**From:** Haig Dalton <[REDACTED]>  
**Sent:** 12 October 2020 11:29  
**To:** Amber Willard  
**Subject:** RE: AW/220/20/HH and AW/241/20/L - further information  
**Attachments:** BCB\_006.jpg; BCB\_007.jpg

DRAWING TITLE
 EXISTING & PROPOSED BATHROOM LAYOUTS

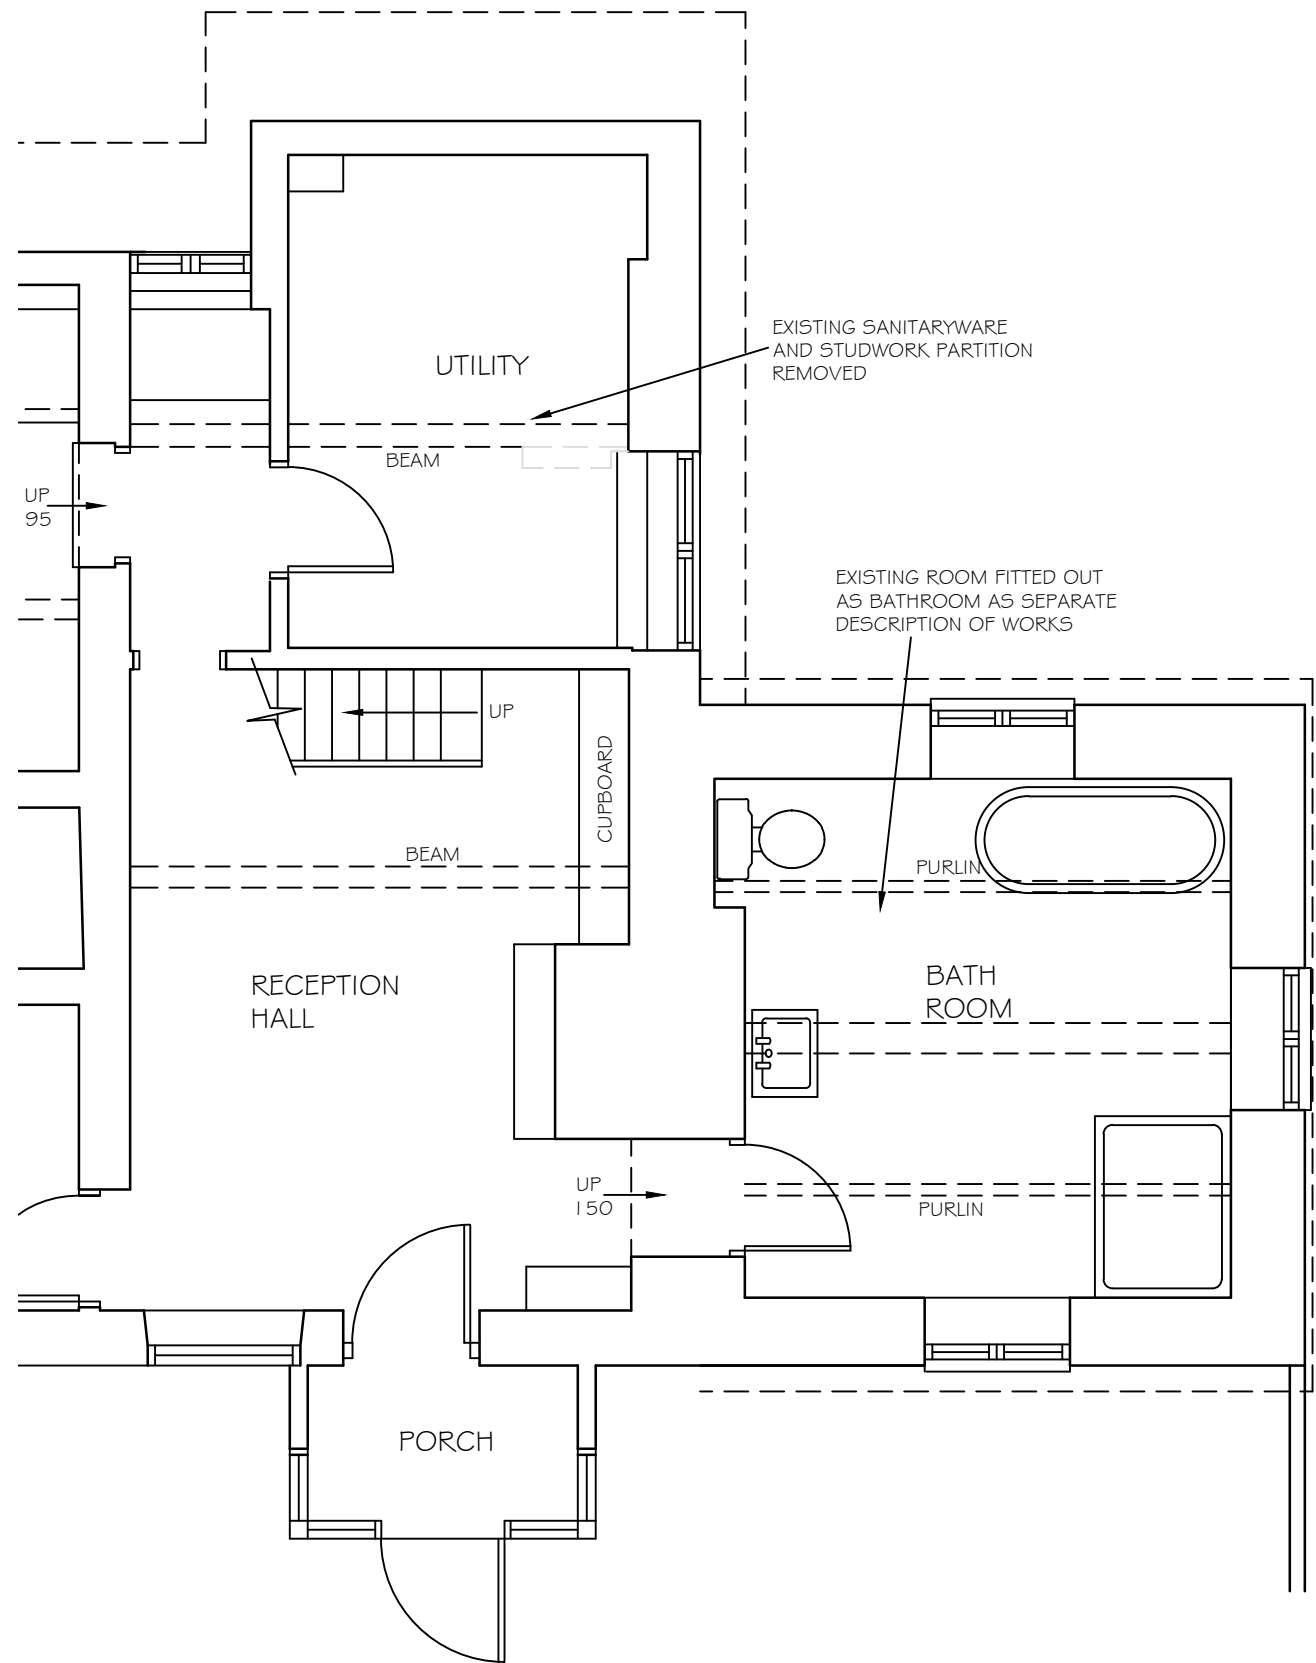
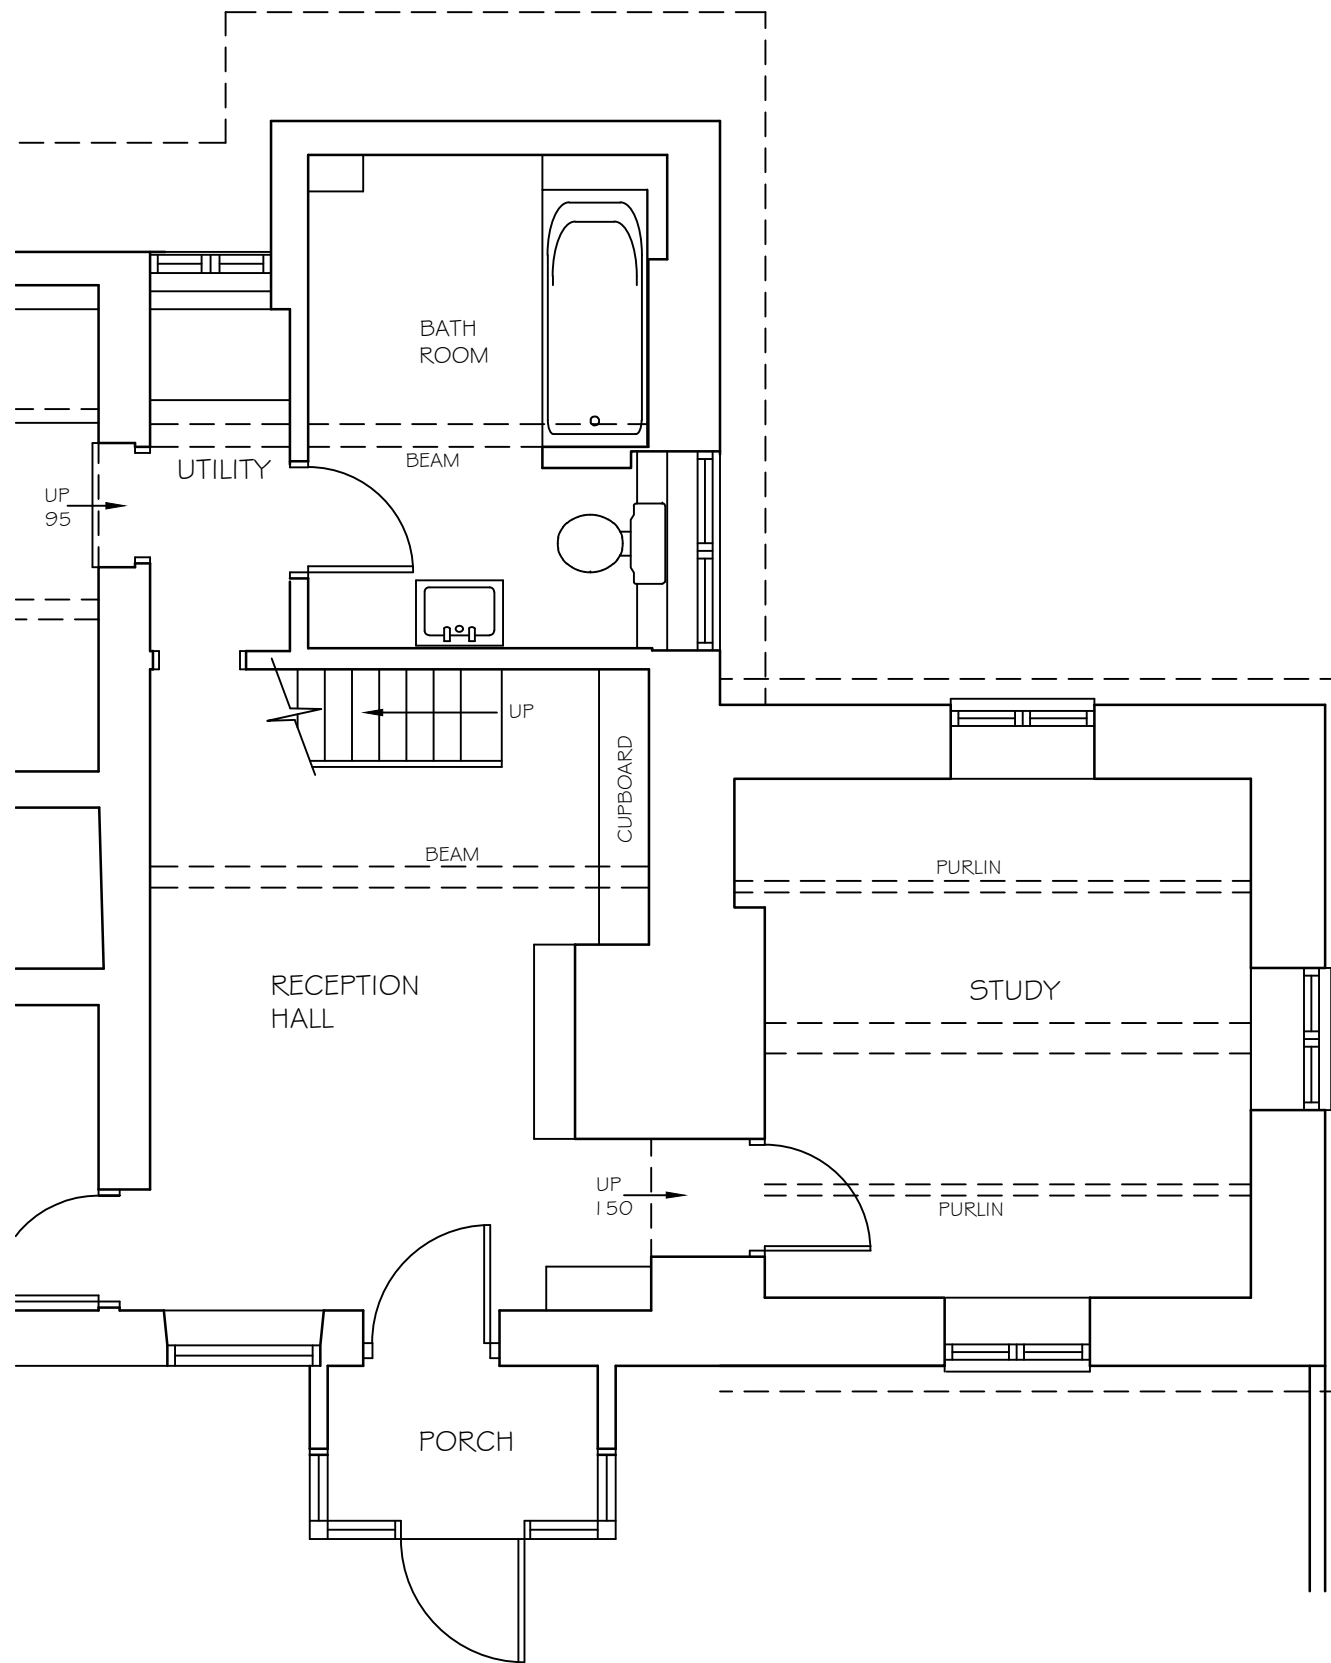
I've just had a look at the plans and the statement and I note all the works are internal except for a single soil pipe being inserted into the outer wall. I wonder if you have a picture of the elevation of how this would appear from the external view.

Further to my email this morning, please find attached images showing the brickwork and course that the new soil pipework would take.

Just to be clear, the path of the new soil pipework would be underground and not visible from the rear elevation itself, entering the new bathroom from under the floor. This is exactly the same application method as the pipework to the existing bathroom.

The new external soil pipe would be made of aluminium finished in black to match the historic downpipes and guttering of the listed building, with the walling made good using lime mortar, in accordance with Historic England best practice.
